From: Martyn White
Sent: 30 August 2019 10:25
To: Planning.Responses <Planning.Responses@arun.gov.uk>
Cc: Anita Gardner <Anita.Gardner@arun.gov.uk>
Subject: CM/38/19/PL & CM/39/19/L

CM/38/19/PL & CM/39/19/L

The Climping Mill site comprises a number of buildings which reflect its various past uses including residential, educational, and agricultural. Of note is the main listed Building (Climping Mill), Mil Thatch and Mill Cottage. The application relates to Mill Cottage which sits to the south west of the Mill and is a curtilage listed structure. It is a modest building with an 'angled L-shaped' plan form.

The Current Proposal

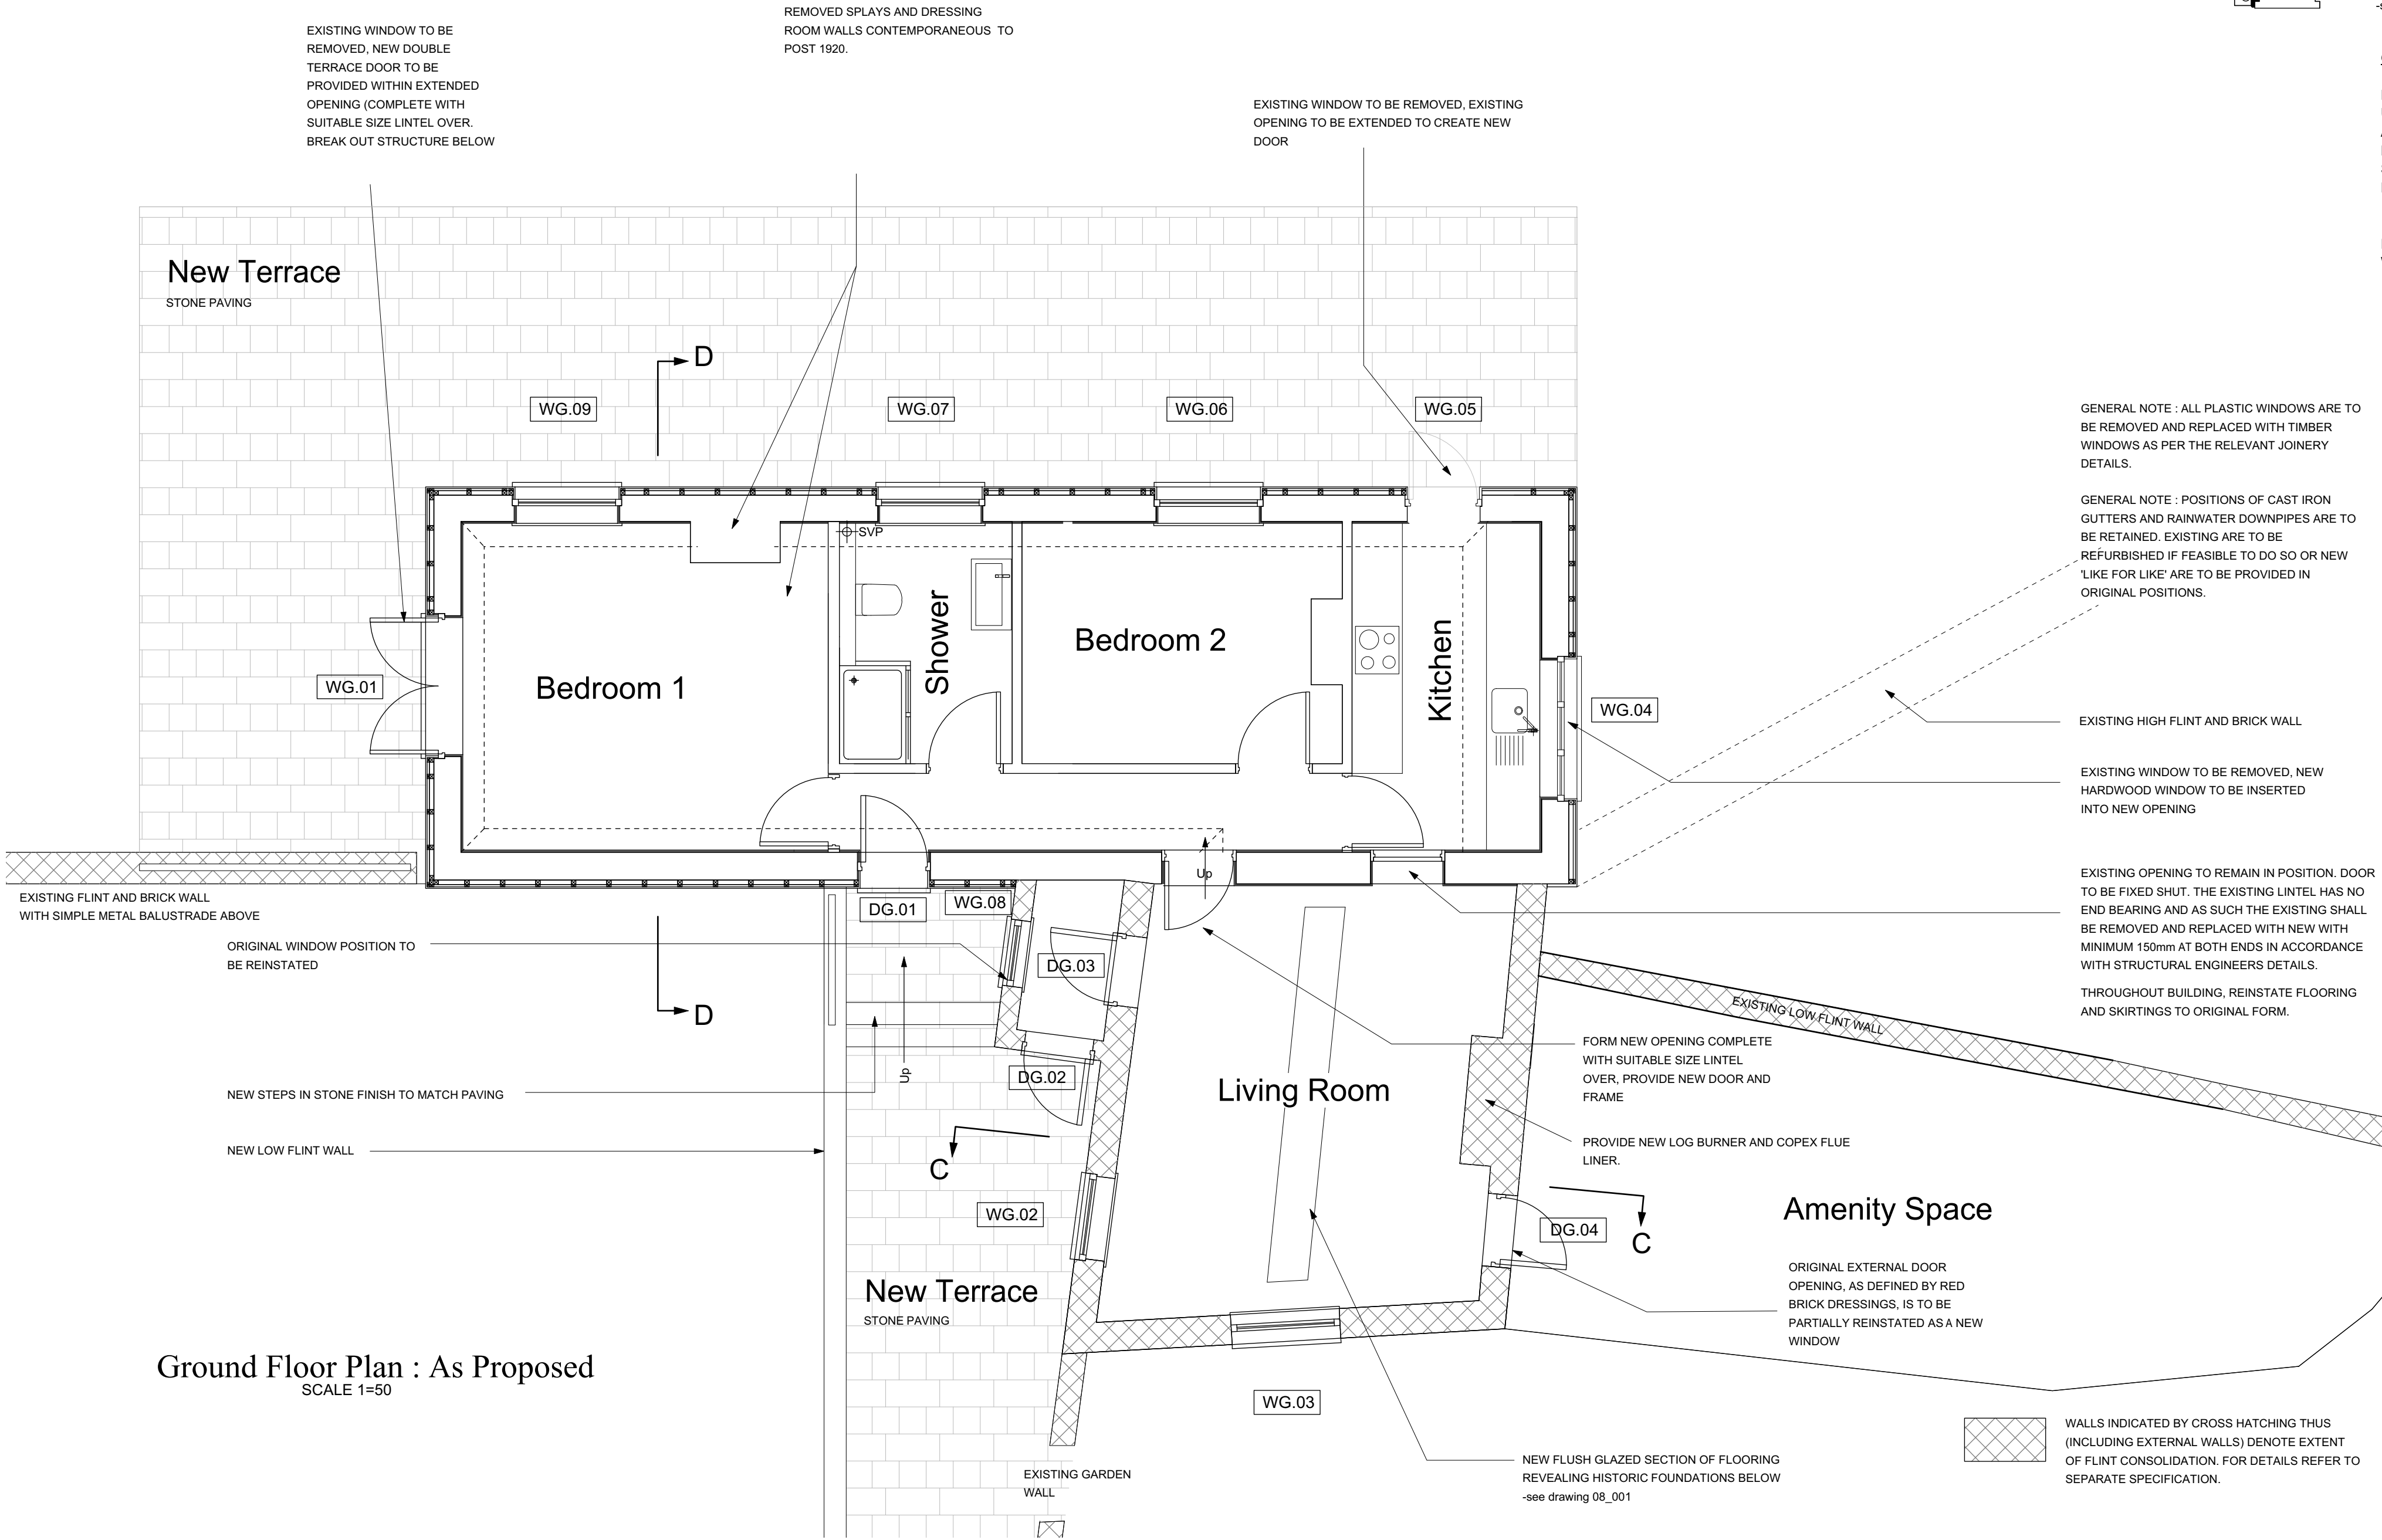
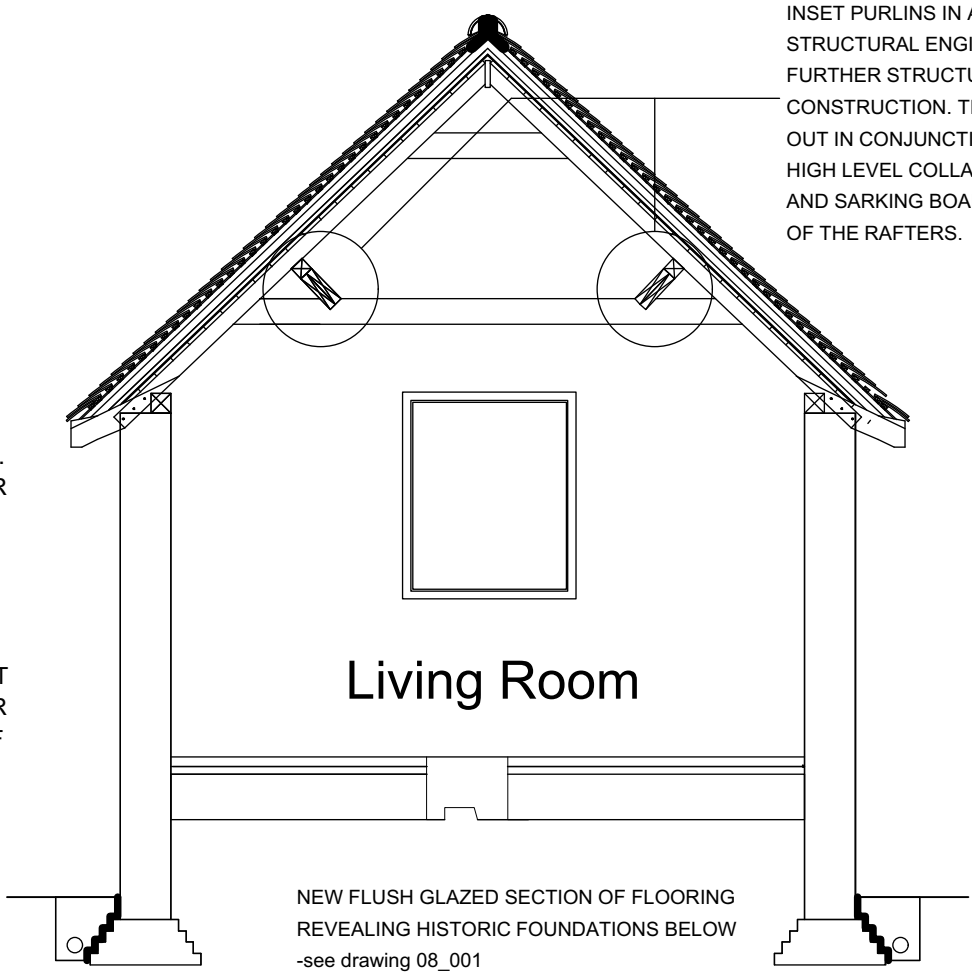
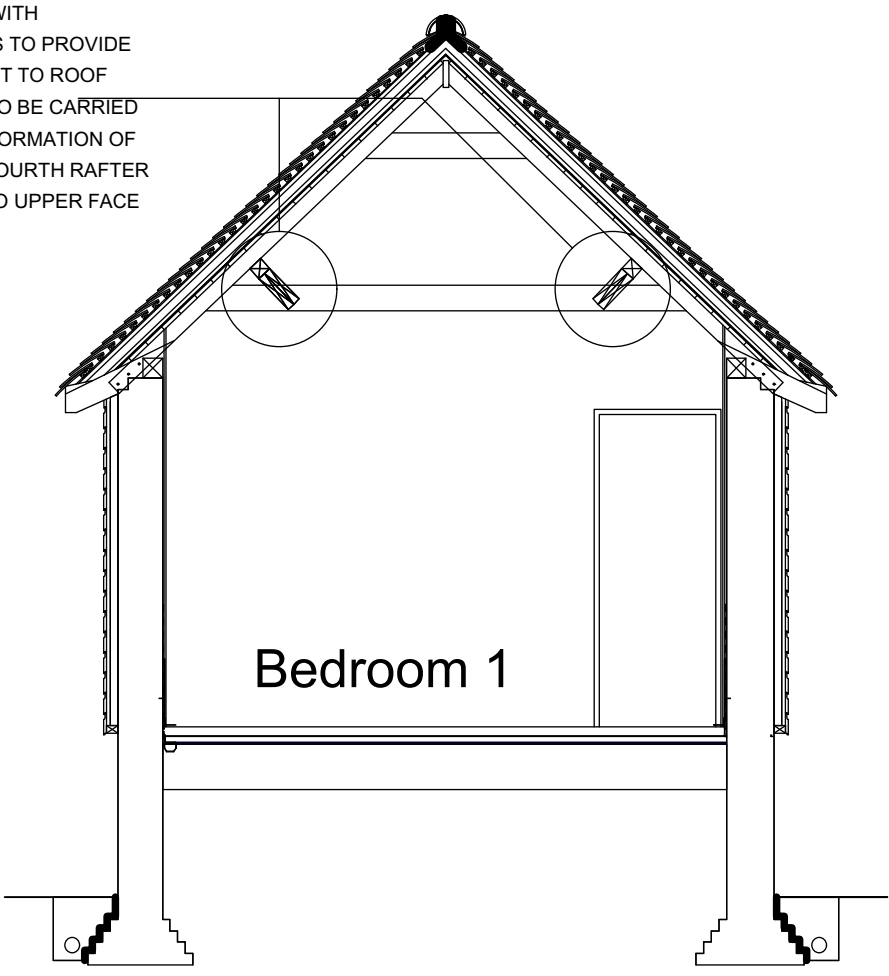
The amendments to the previously approved layout are minimal, and will not harm the character of the space. Such a proposal will allow the internal space to be better used by the future occupiers. However, it is not clear what the flooring will be. Reference is made to re-instate flooring and skirting to original form.

The section of flush glazed flooring in the living room will introduce an interesting feature to the space. The justification for such a feature is questioned. However, on balance, it is considered to have a neutral impact upon the character/significance of the building.

Two new terraces will be created; one to the front of the building and another one to the side and rear. The area to the front will presumably serve the Mill thatch building.

The second terrace is substantial in size, and the quality of the stone used will have a significant impact. Details of the stone paving should be provided to the LPA by way of condition in order to ensure that it reflects the character of the listed building. On balance, the concept is considered to be acceptable subject to details.

The new section of walling for the front terrace will be required to reflect the quality of the existing walling. A sample panel could be provided in order to ensure that the quality is acceptable.

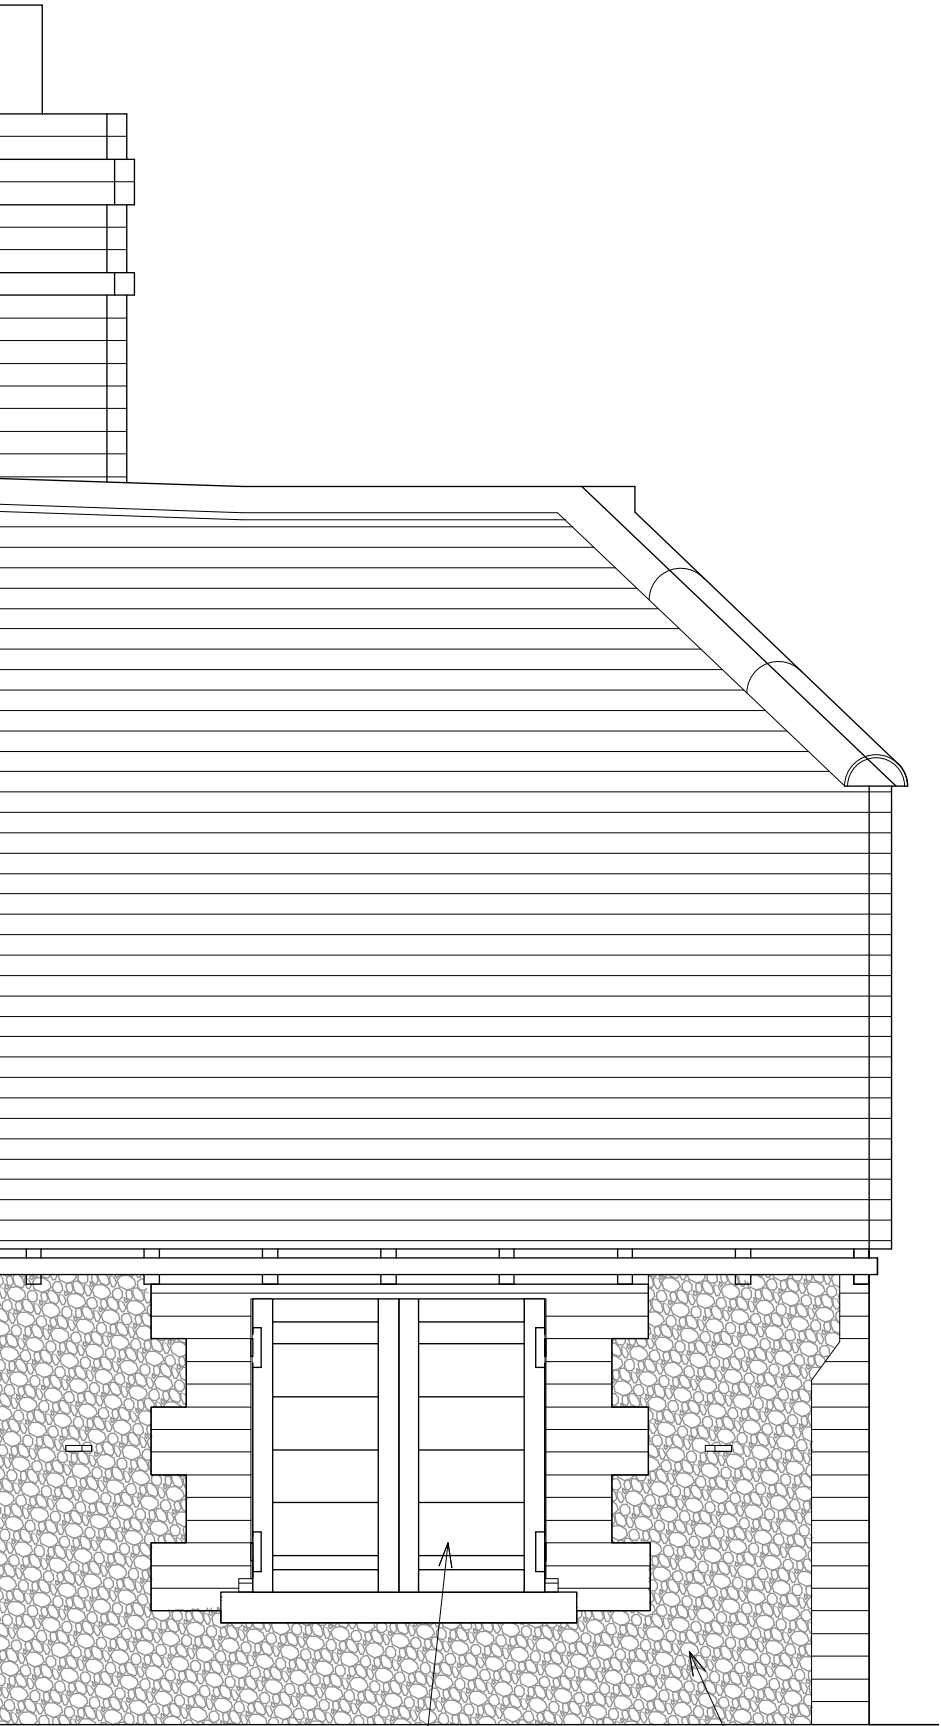
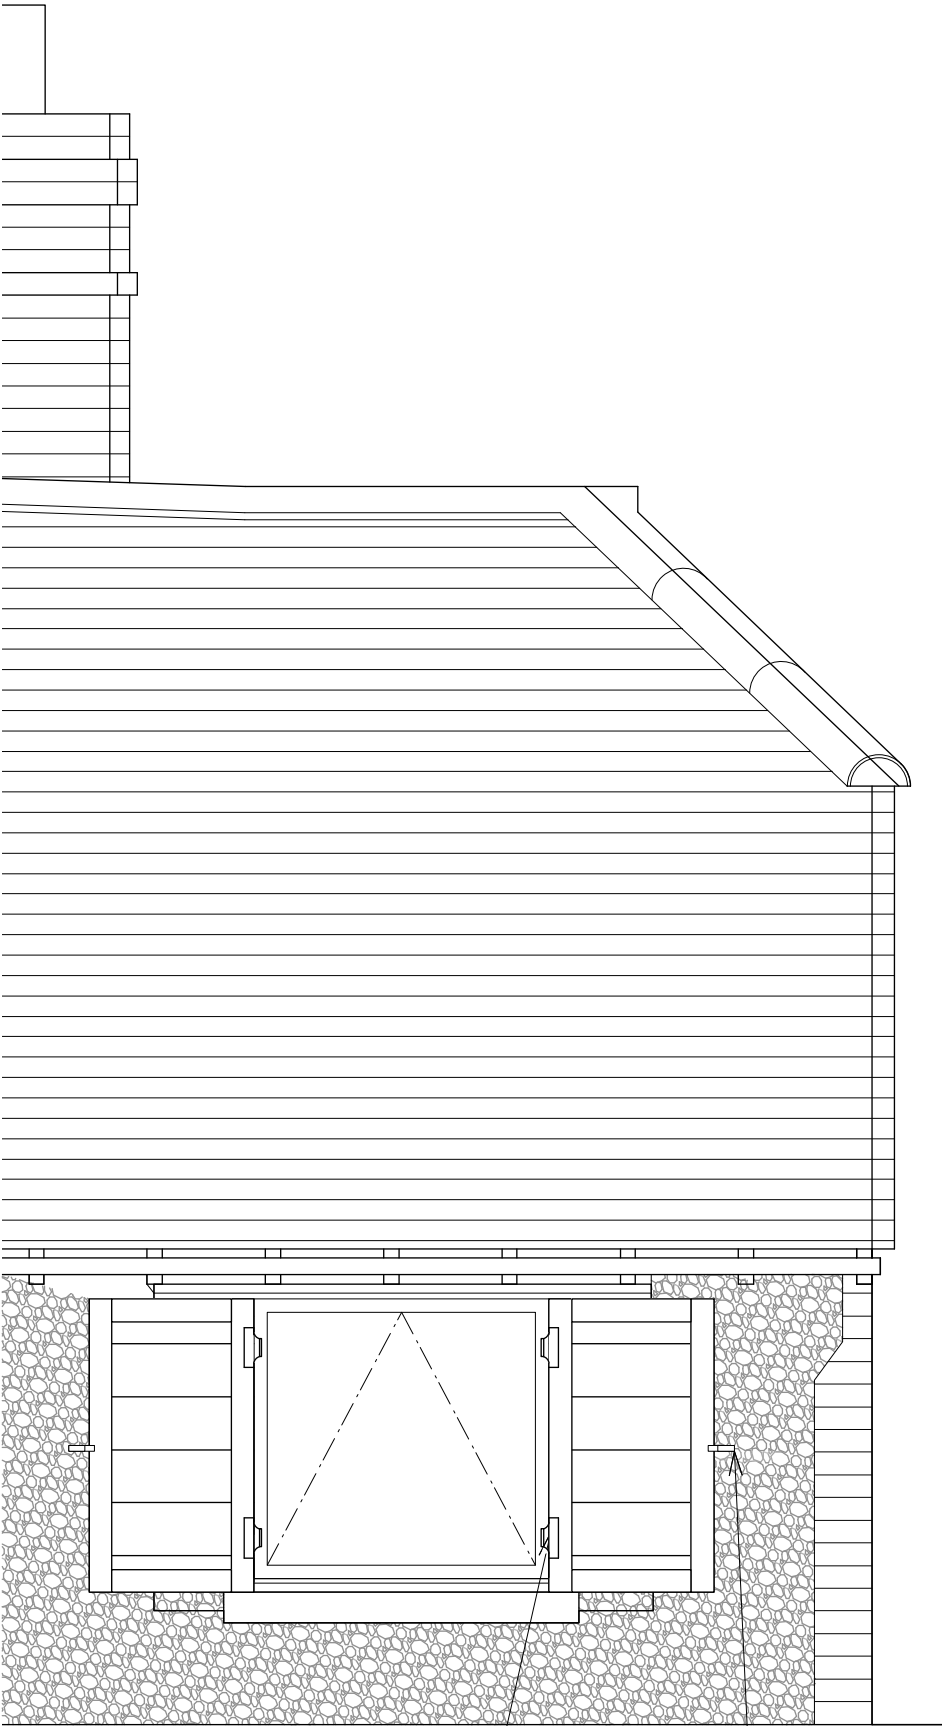
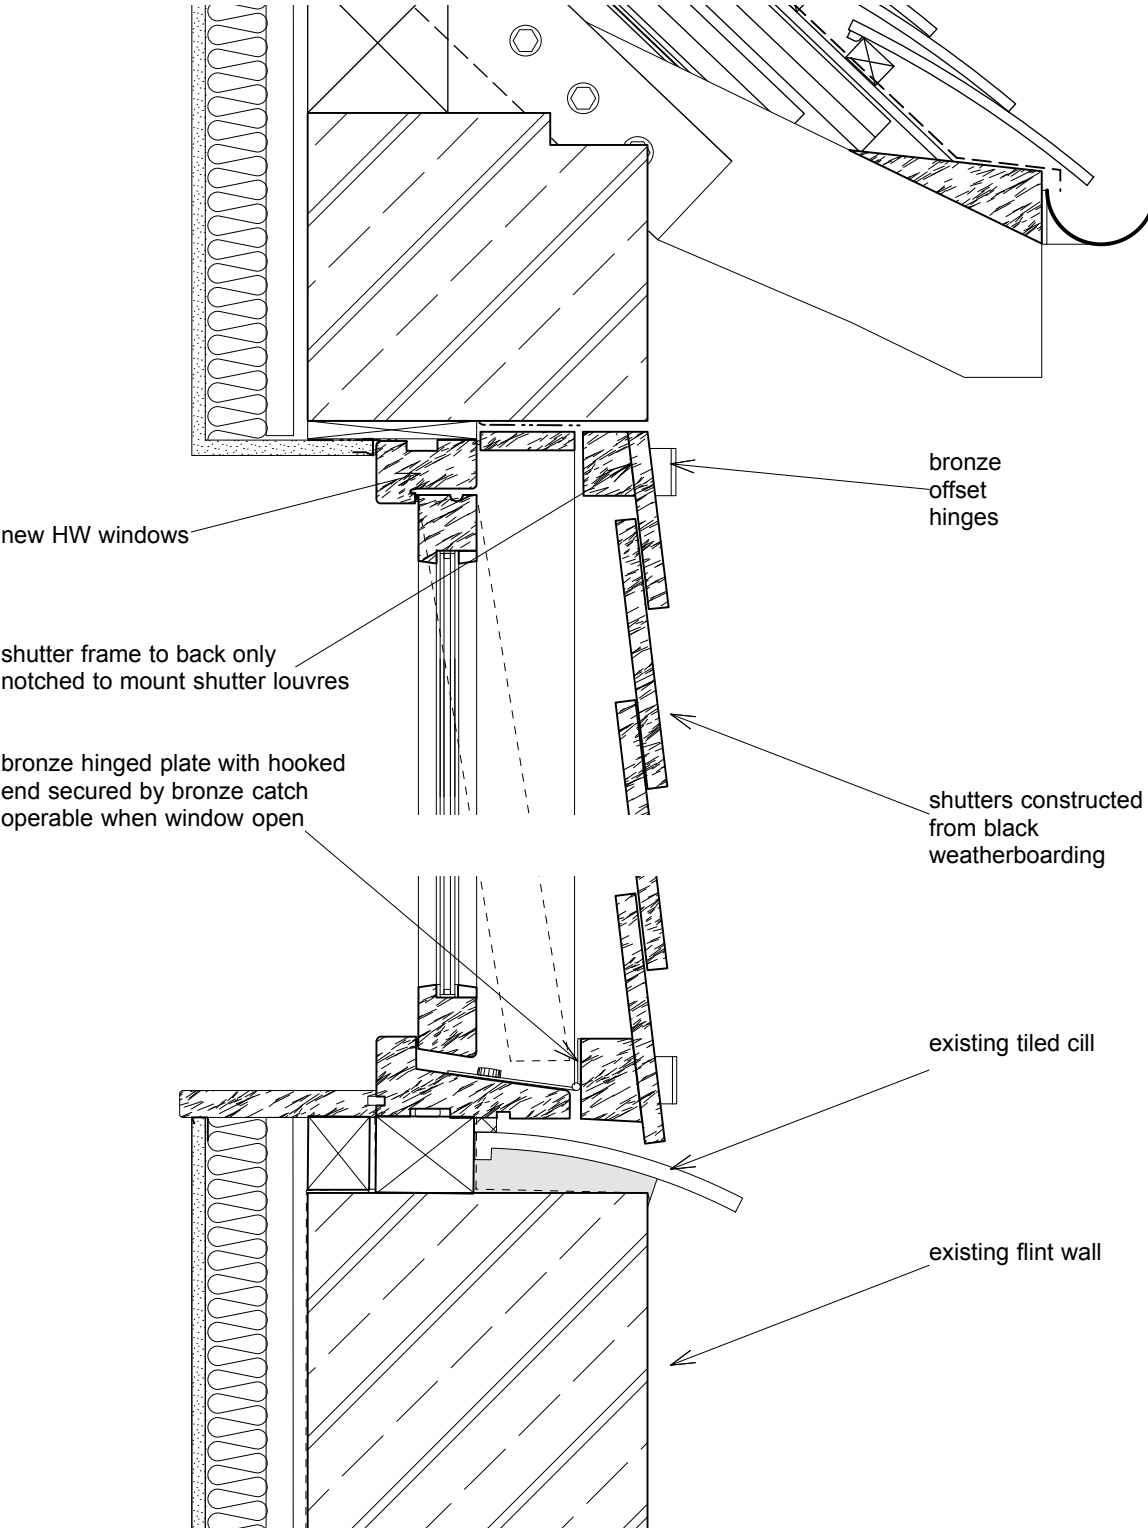
A historical photograph has been provided as evidence for their reintroduction on the building. This approach is considered to be most successful on the elevations where timber cladding has previously been approved. The introduction of the shutters on the other elevations will have to be carefully designed and considered so that they do not look like inappropriate introductions. Details have been provided for the sections of elevations covered with cladding, but not those elevations treated with flint. Such information should be supplied and discussed with the LPA.
